**J.S. THOMPSON**  
ENGINEERING, INC

May 22, 2024

The "Oakwood" plan was reviewed for lot #3 Pondhurst subdivision in Fuquay-Varina, North Carolina to address the missing extra joists above the master suite and laundry rooms.

LOT #3 PONDHURST  
ELM STREET BUILDERS

S-2
SECOND FLOOR FRAMING PLAN

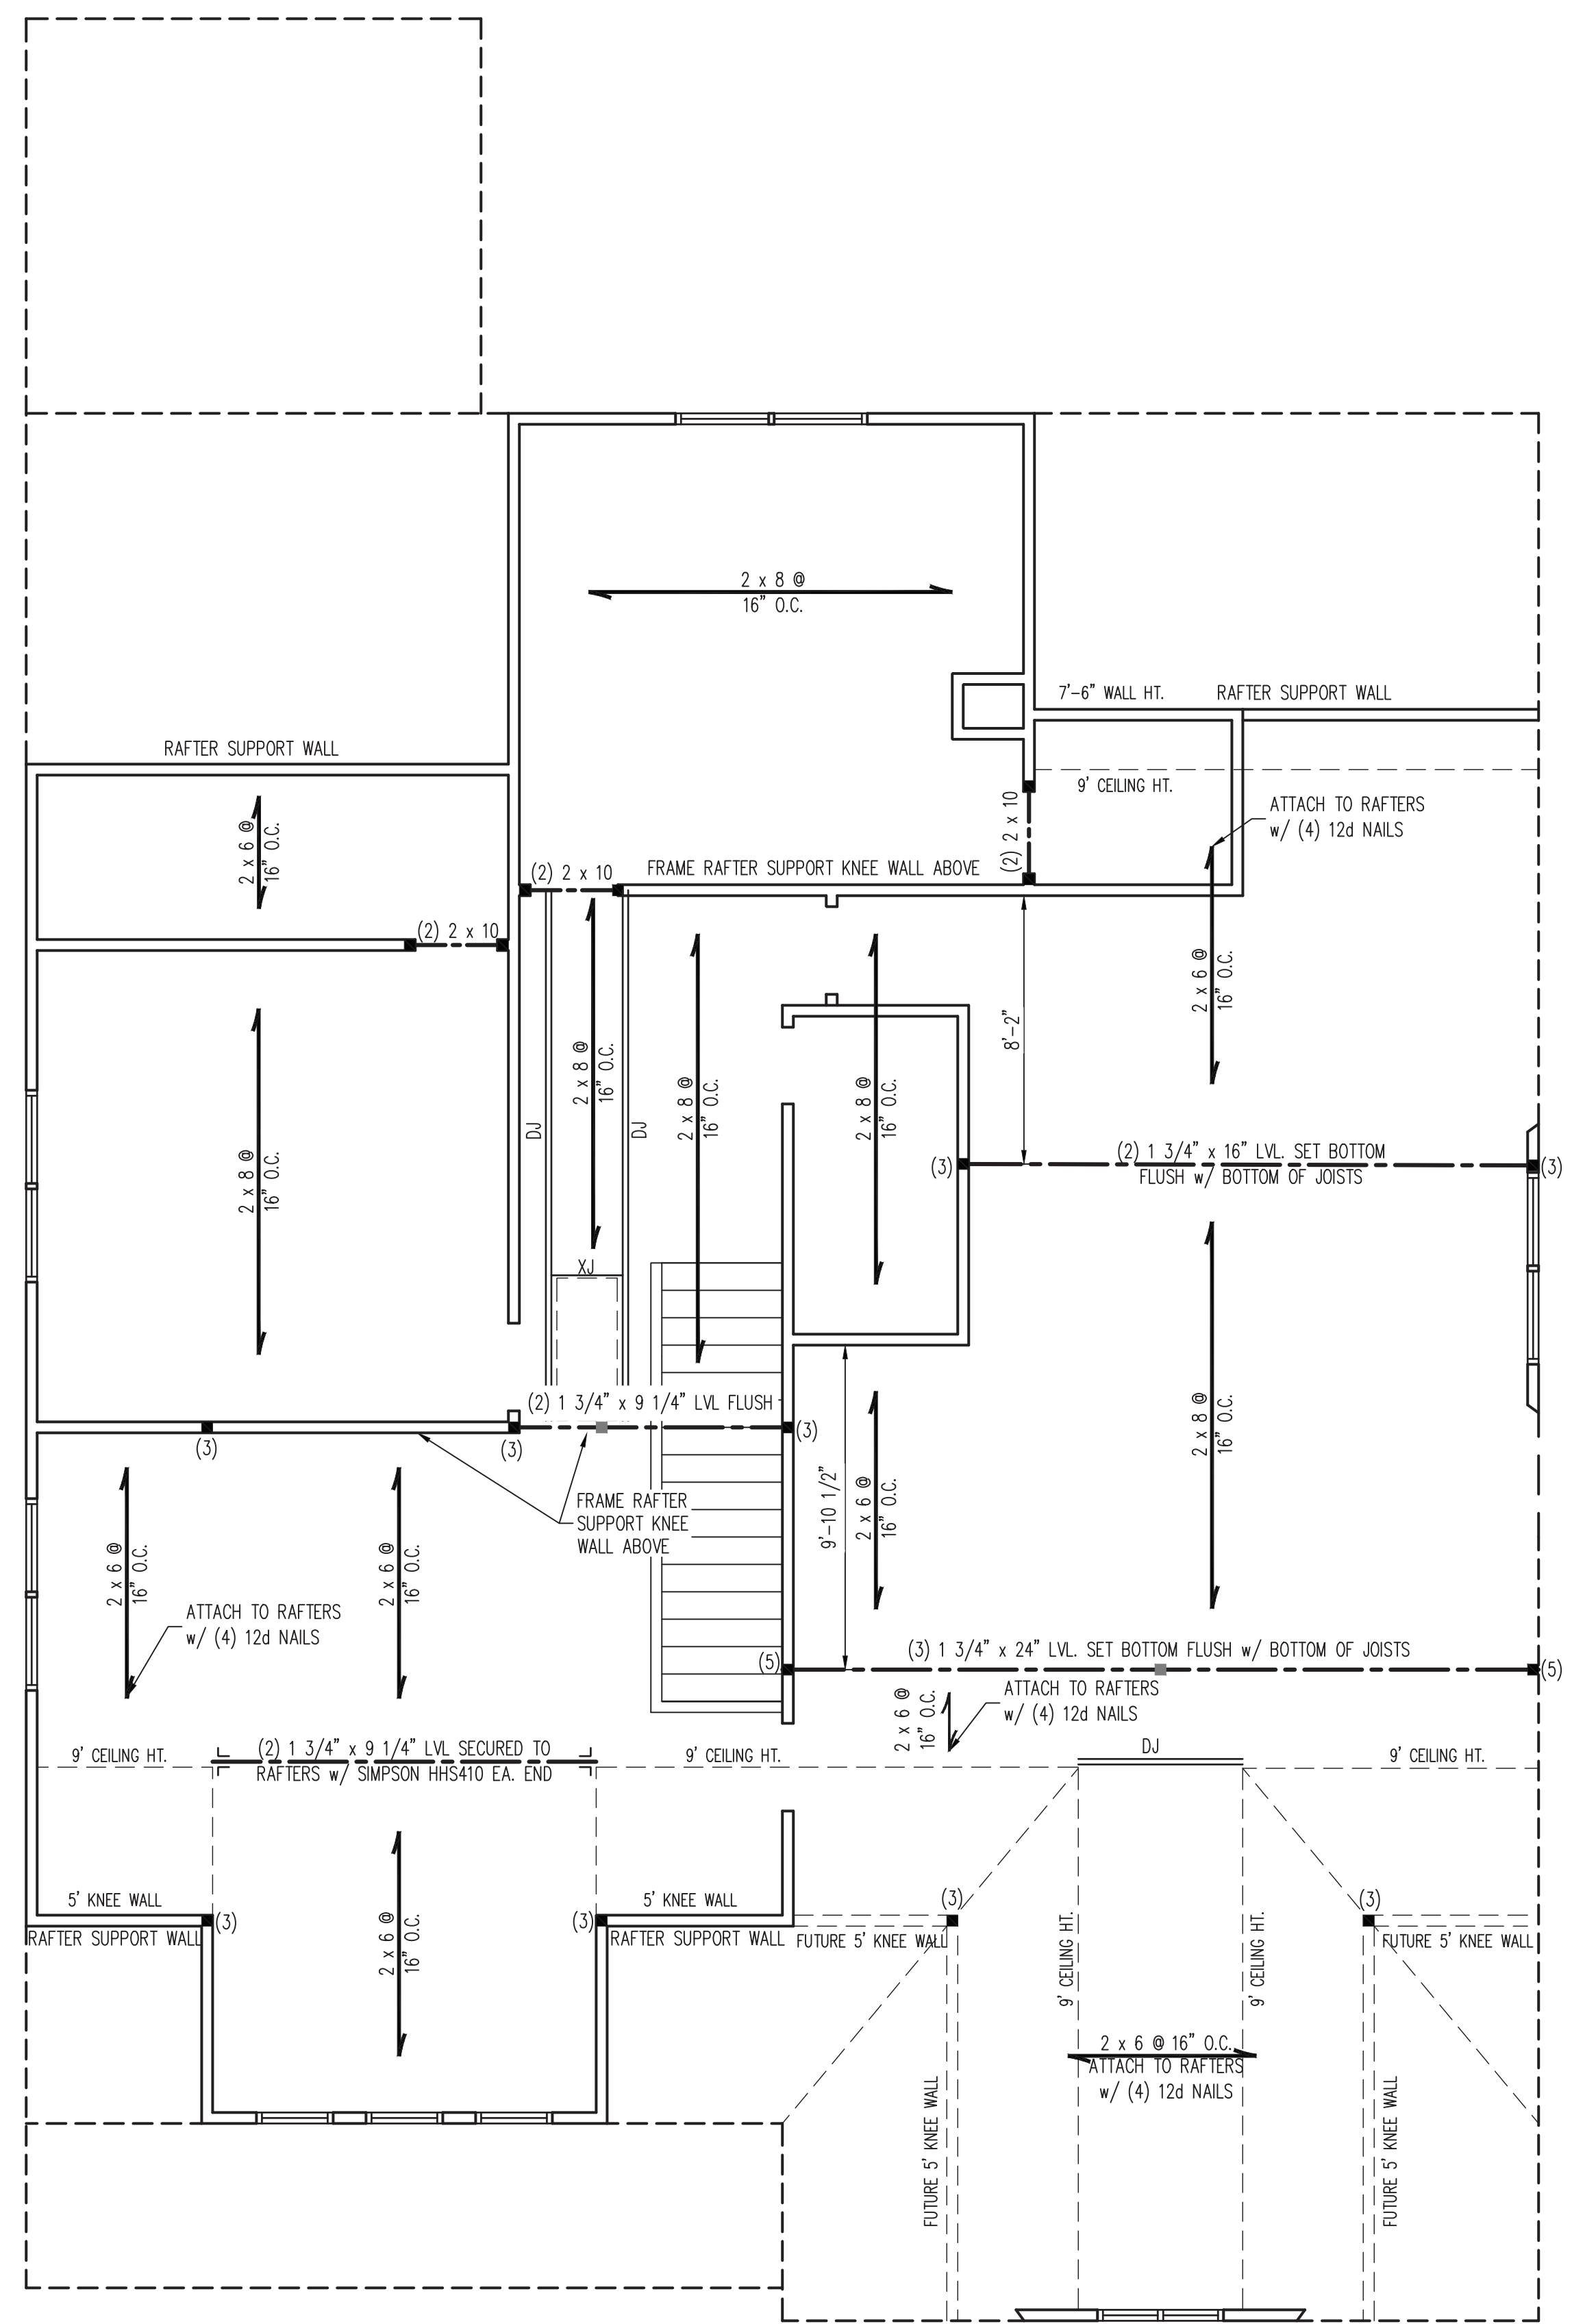
The extra joists above the master suite and laundry room were not installed per plan and were incorporated into the I-joist layout. I-joist "T" blocking is to be installed between the noted joists per the attached detail to support the additional loads imposed by the walls above. This configuration will provide the required support for all applied loads.
